DOC17/249631
SSD8183

Beryl Solar Farm (SSD 8183) - Exhibited EIS

OEH Recommendations

Beryl Solar Farm – Environmental Impact Statement

Figure 8-2 Updated Biodiversity Assessment Report Vegetation zones

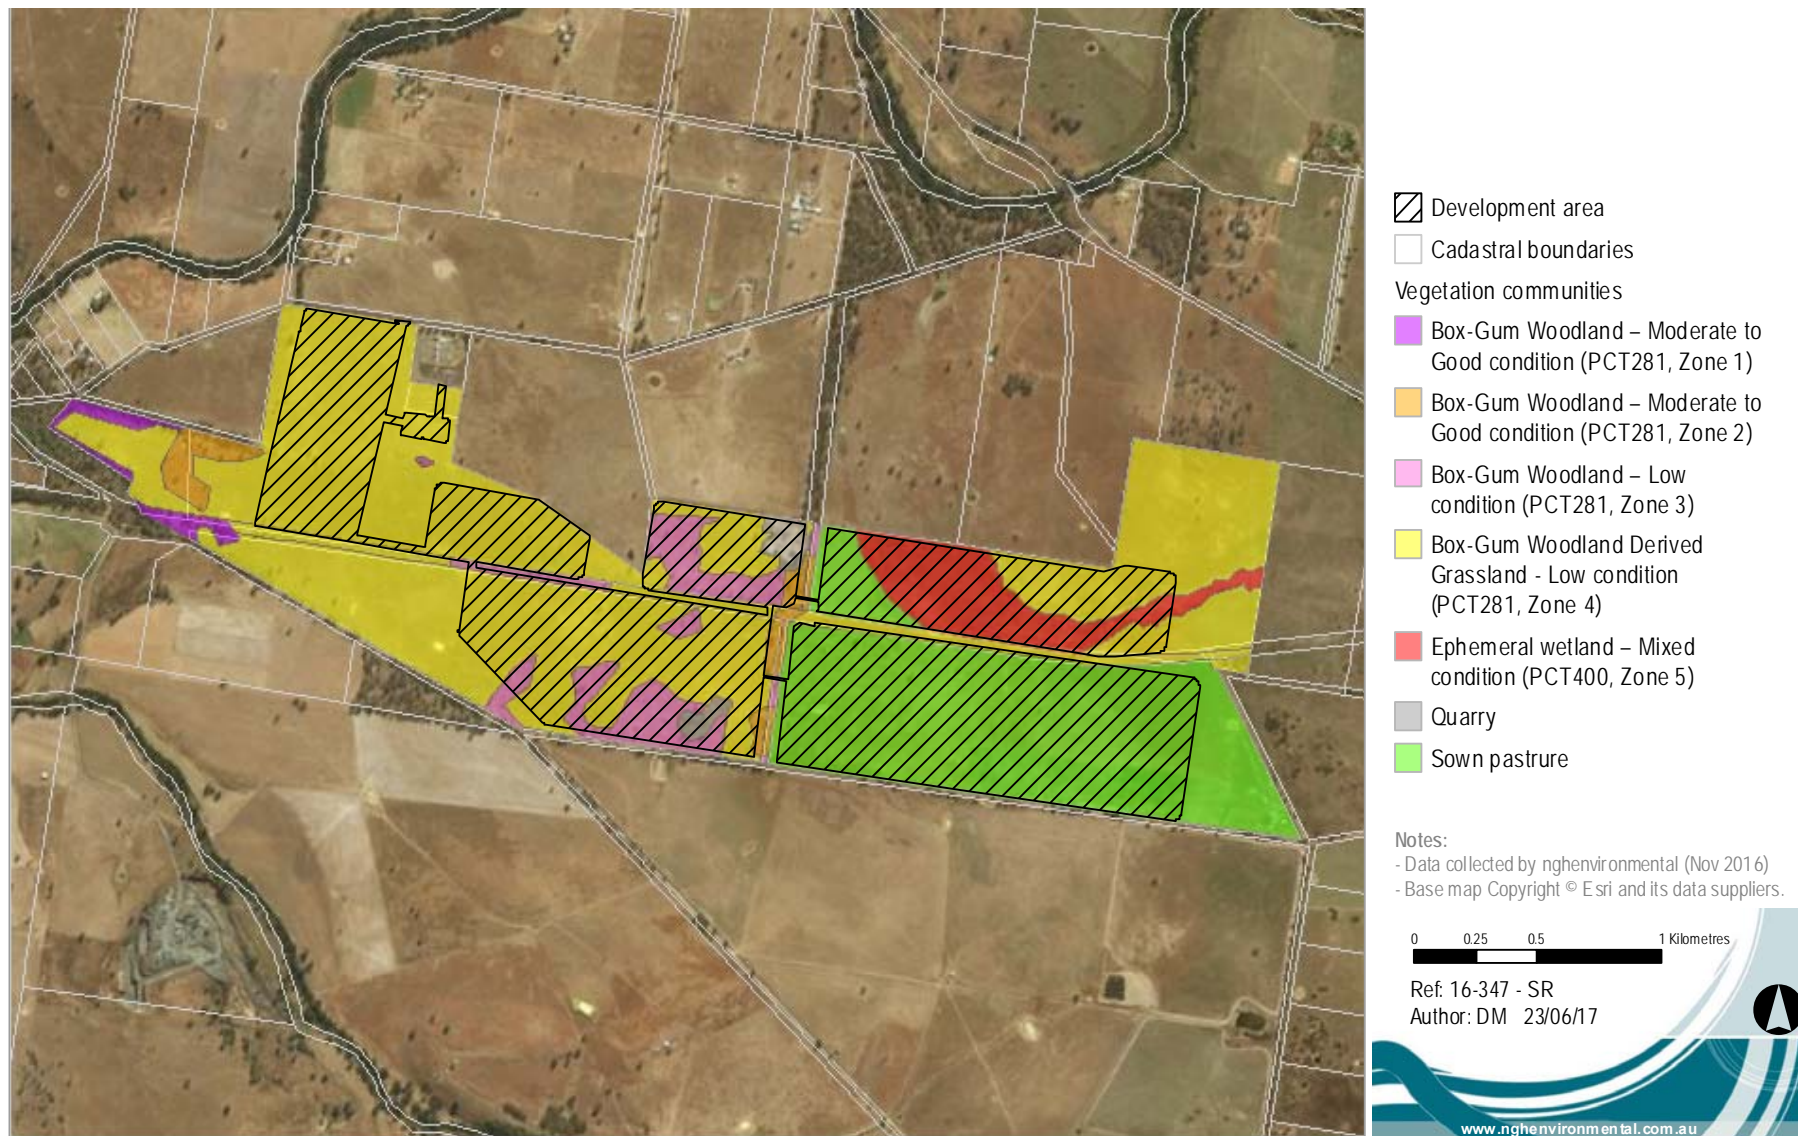
1. Details should be provided to justify the differences between each of the vegetation zones in Table 3.2 mapped by the proponent.

The proponent has mapped five Box-Gum Woodland vegetation zones within the project site but has not provided details of the structural and/or floristic differences between the zones. OEH is unable to determine if the vegetation zones have been identified appropriately which may influence the number of credits generated by the project. The proponent should provide a structural and floristic description of each of the vegetation zones, including notable differences between the zones. Any other differences between the zones (e.g. soil type, past management, etc.) should also be described.

2. Details should be provided to justify why each of the vegetation zones in Table 3.2 have, or haven't been identified as threatened ecological communities.

The BAR simply states whether each vegetation zone is a threatened ecological community or not. The BAR fails to detail why each vegetation zone in Table 3.2 does, or doesn't, form part of the White Box Yellow Box Blakely's Red Gum Woodland Endangered Ecological Community (EEC) listed on the *Threatened Species Conservation Act 1995* (TSC Act) or the White Box-Yellow Box-Blakely's Red Gum Grassy Woodland and Derived Native Grassland Critically Endangered Ecological Community (CEEC) listed on the *Environment Protection and Biodiversity Conservation Act 1999* (EPBC Act).

The BAR does not provide comparison of the vegetation zones against the threatened ecological community listings. Details should be provided comparing the characteristics of the vegetation zones against the final determinations of the threatened ecological communities. OEH is unable to determine the appropriateness of the threatened ecological community mapping without further explanation by the proponent.
